SSD-10416 Powerhouse Parramatta

TAB A – Detailed Comment on SSD-10416

Figure 1 Proposed site plan

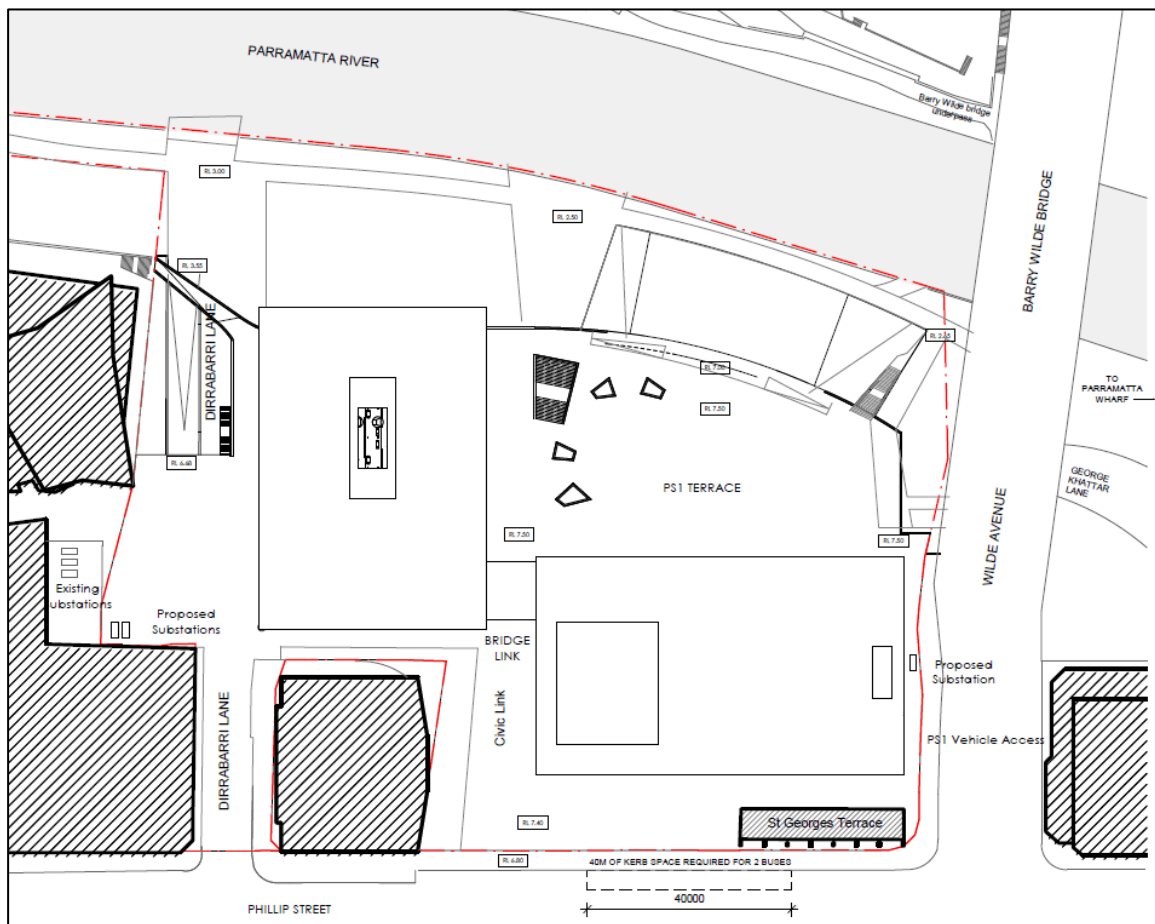
The applicant should be advised that Wilde Avenue is a key bus corridor with provision of a dedicated bus lane. The proposed vehicular access on Wilde Avenue to facilitate the scheduled servicing of Presentation Space 1 with vehicles up to 19m in length would potentially compromise the effective operation of bus services.

Alternative heavy vehicle access to the site should be investigated to avoid the use of Wilde Avenue.
